CITY OF ALBUQUERQUE

December 4, 2017

Re: McDonalds - Gibson

5001 Gibson Blvd. SE Traffic Circulation Layout

C4.1

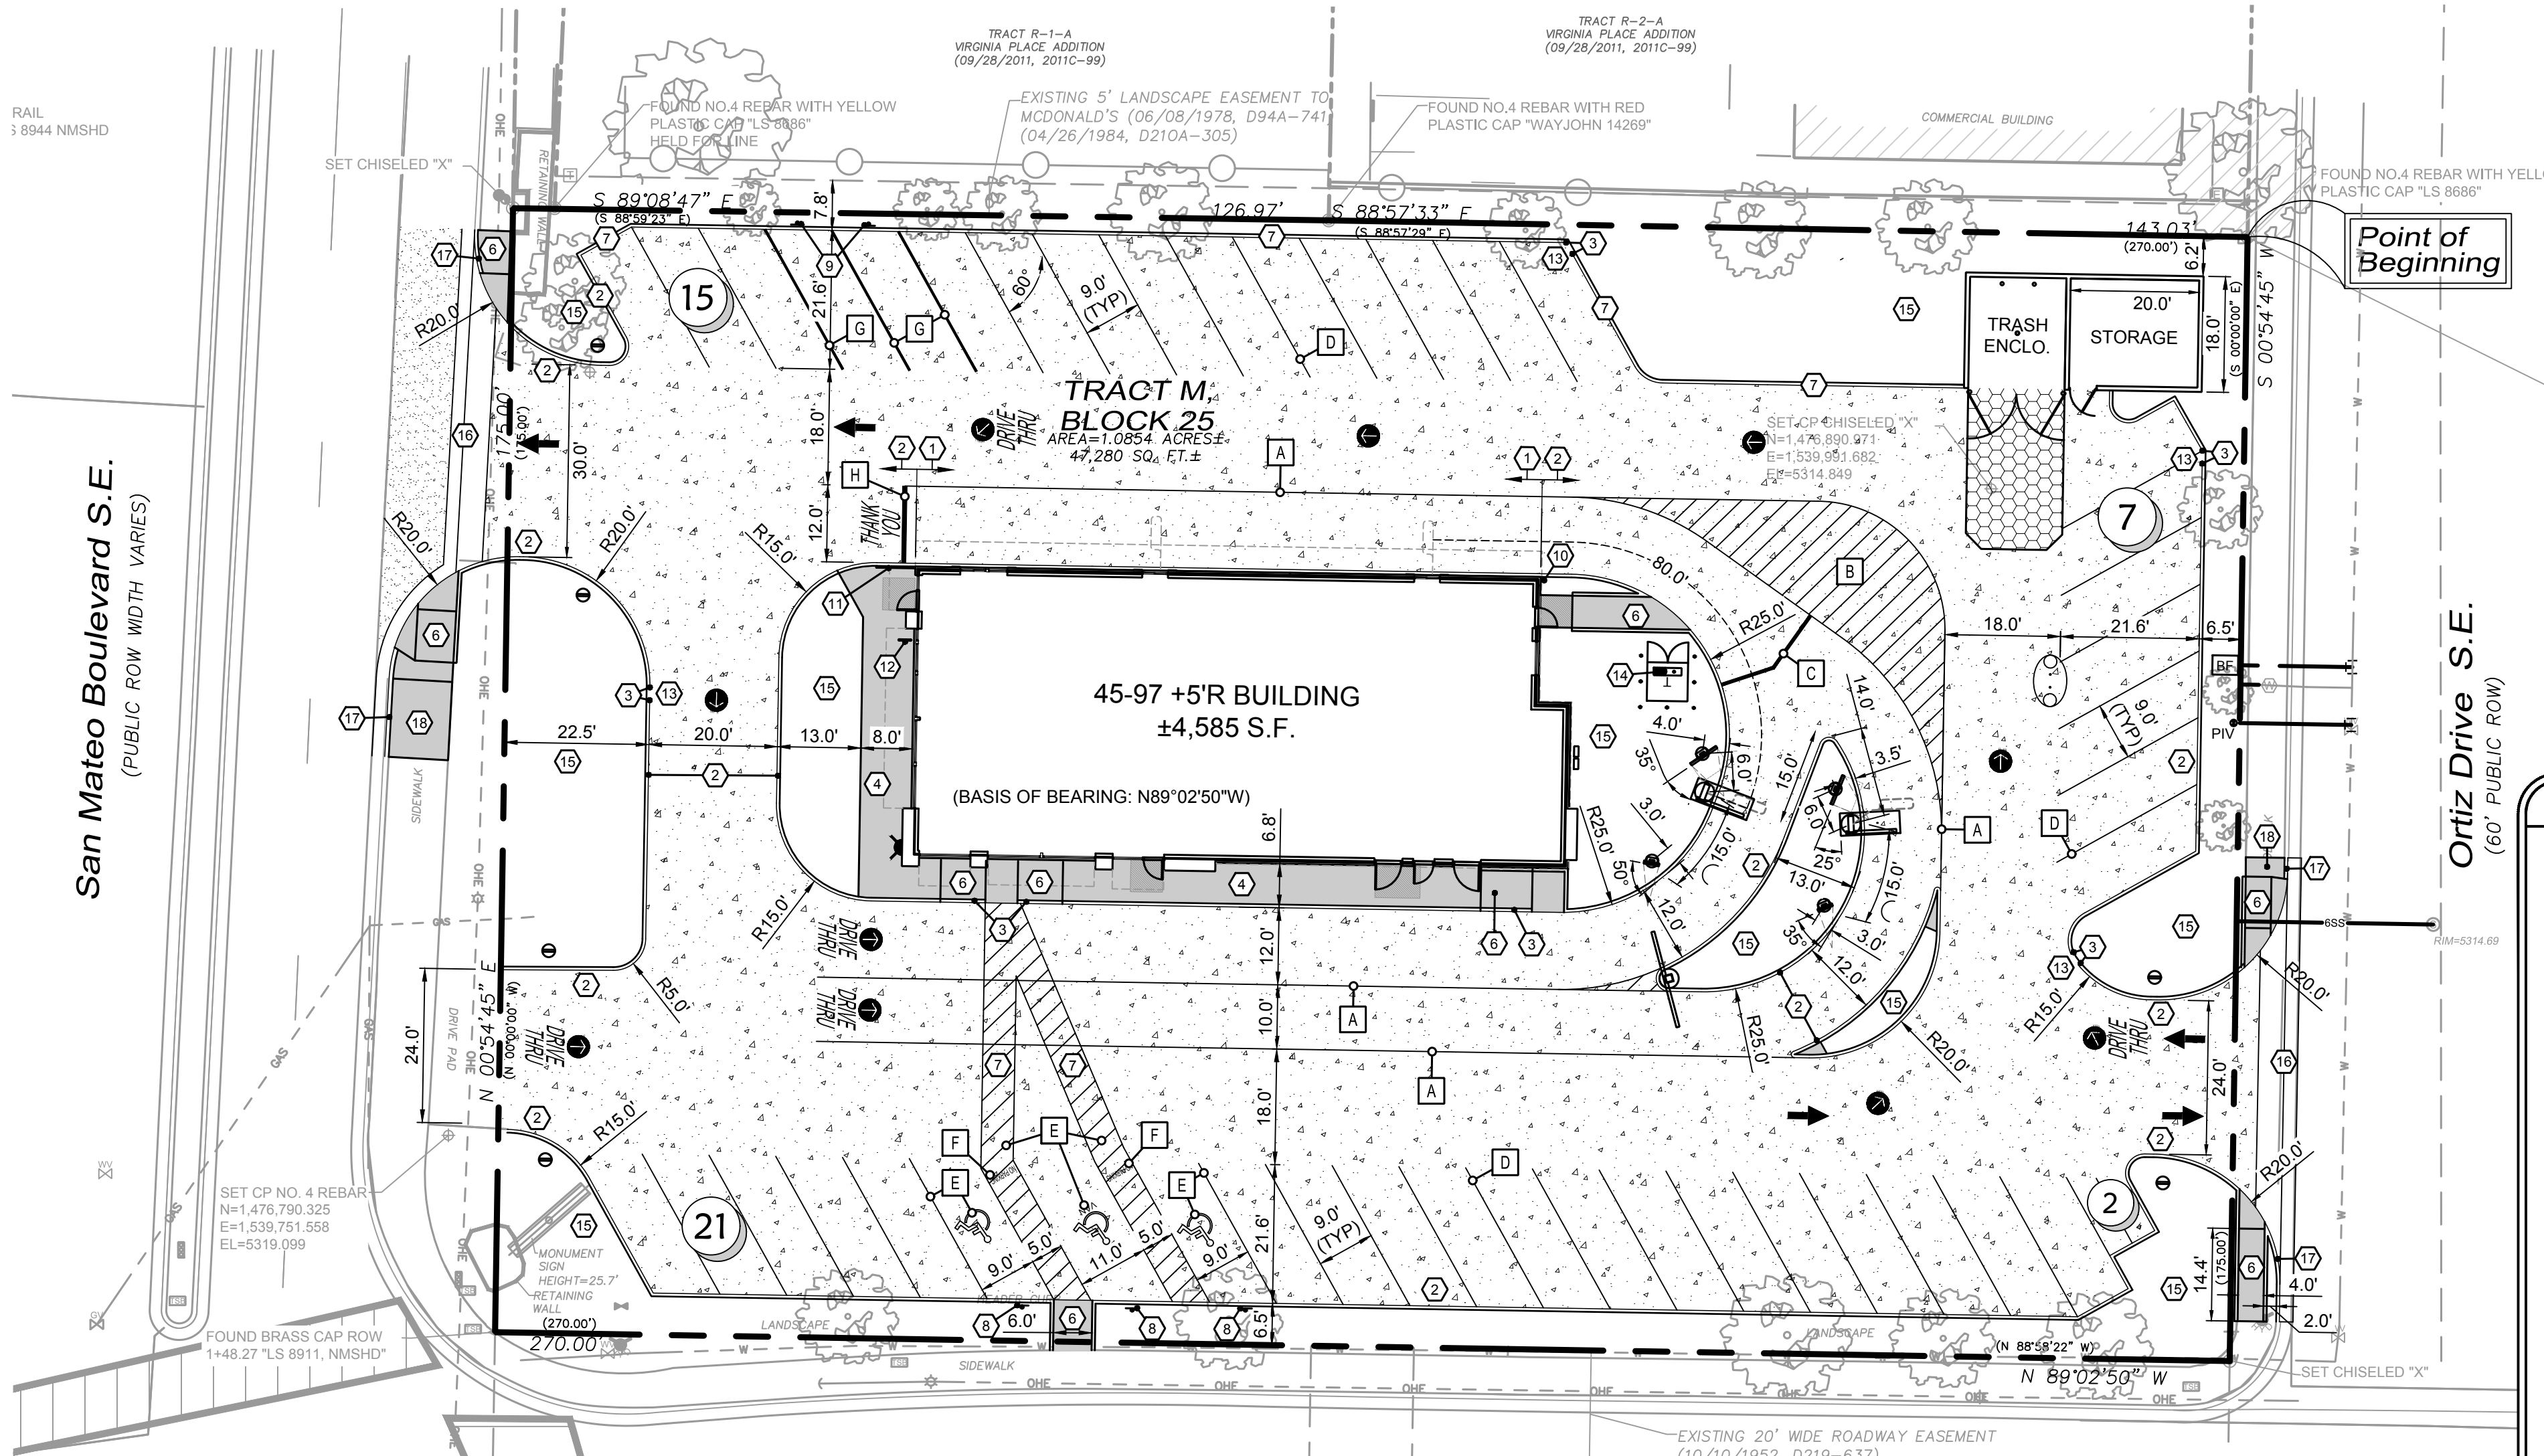
- 1. The traffic circulation layout must be stamped, signed, and dated by an engineer or architect licensed in the state of New Mexico.
- The ADA accessible parking sign must have the required language per 66-7-352.4C NMSA 1978 "Violators Are Subject to a Fine and/or Towing." Please call out detail and location of HC signs.

- ADA curb ramps in public right of way (ROW) must be updated to current standards and have truncated domes installed.
- 4. Motorcycle parking spaces shall be designated by its own conspicuously posted upright sign, either free-standing or wall mounted per the zoning code.

- 5. Per the zoning code, a 6 ft. wide ADA accessible pedestrian pathway is required from the public sidewalk to the building entrances. Please make the connection from the Public ROW to the building 6 feet.

- 6. You can eliminate the striping on the ADA path from the standard ADA parking spot to the building.
- One-way vehicular paths require pavement directional signage and a posted "Do Not Enter" sign at the point of egress. Please show detail and location of posted signs.

- 8. Unused curb cuts must be replaced with sidewalk and curb & gutter. A build note must be provided referring to the appropriate City Standard drawing.
